**re: Grading Plan Review**  
**Proposed Project X Development**  
**99 Bill Leathem Drive, 2 & 20 Leikin Drive & 11 Beckstead Road - Ottawa, Ontario**

**date:** January 15, 2025

**file:** PG5876-MEMO.07

DRAWING NAME
GRADING PLAN
NORTH EASTERN QUADRANT

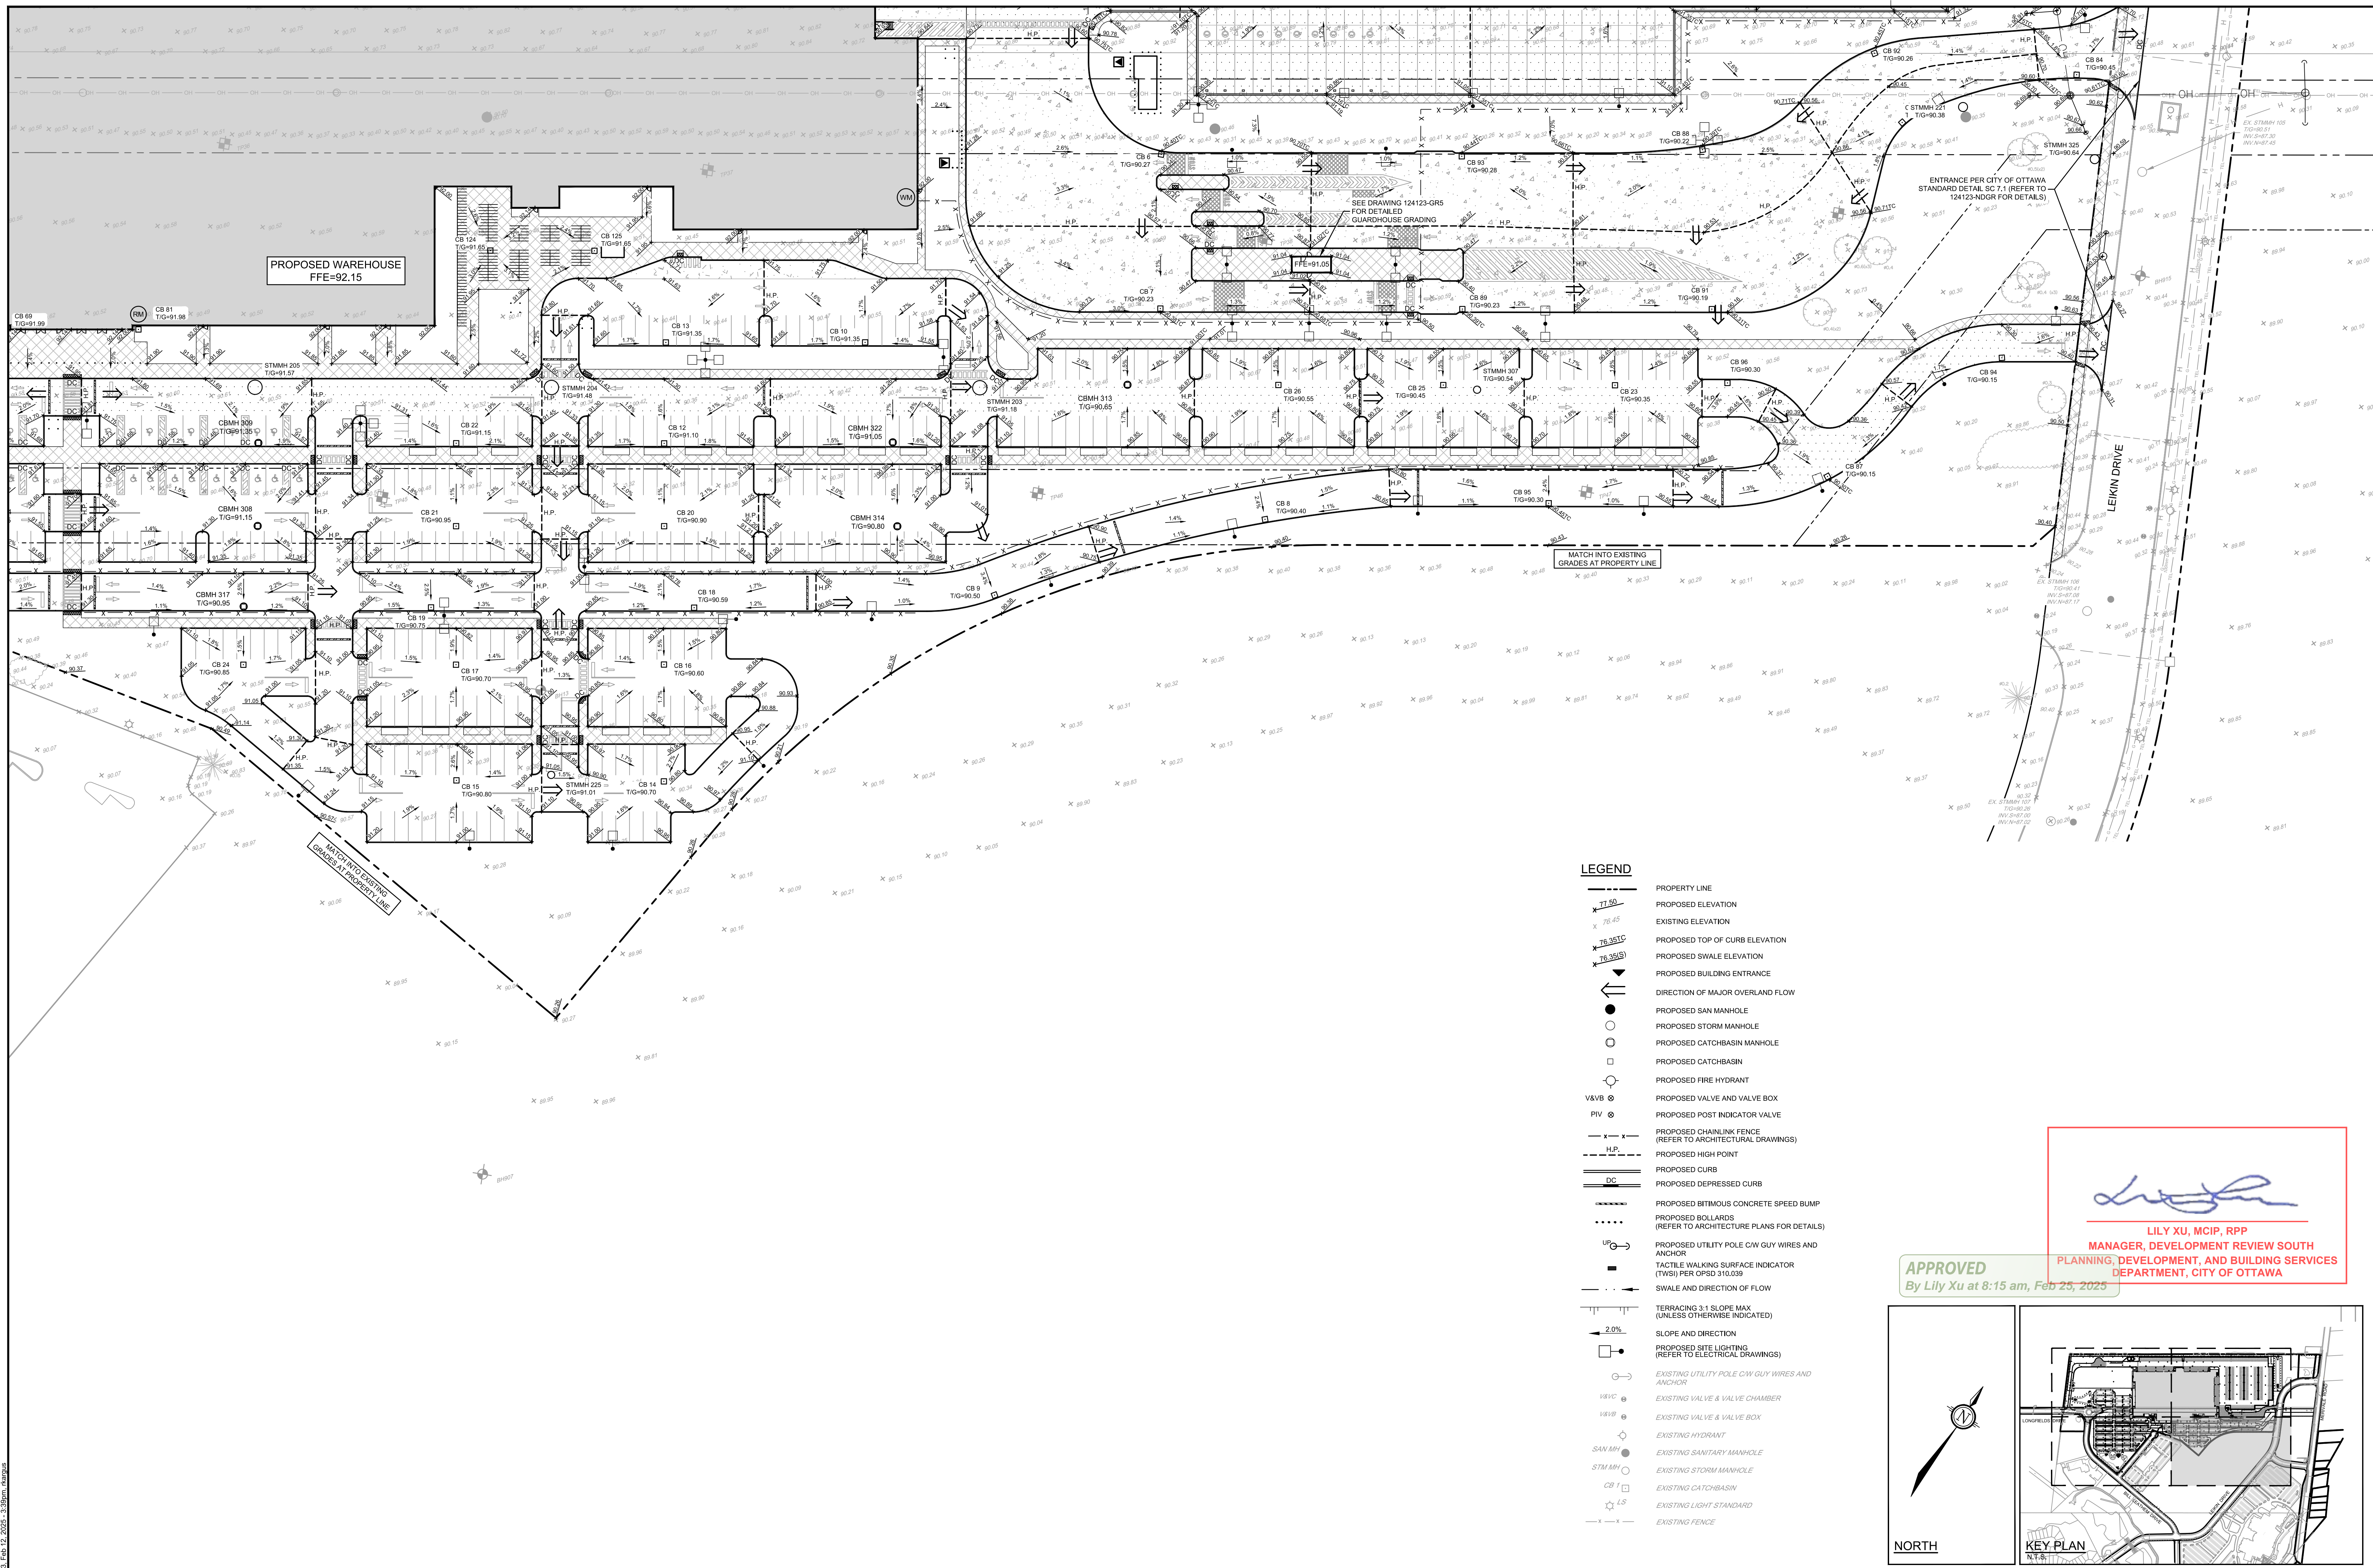
Based on our review of these Grading Plans, the finished floor elevation of the proposed building will be 92.15 m, which is approximately 1.65 m above the current site grade at geodetic elevation 90.5 m.

This exceeds the permissible grade raise restriction of 0.4 m for the proposed building by about 1.2 m. Accordingly, a 1.2 m thickness of lightweight fill (LWF) is required under the slab-on-grade for the warehouse portion of the structure, and a 0.9 m thickness of LWF is required under the slab-on-grade of the more lightly-loaded office portion of the

structure. Some additional LWF is also required immediately around portions of the proposed building.

The LWF details are shown on the attached drawing PG5876-G1, and which is also provided in Appendix 2 of the current Geotechnical Investigation Report, referenced above.
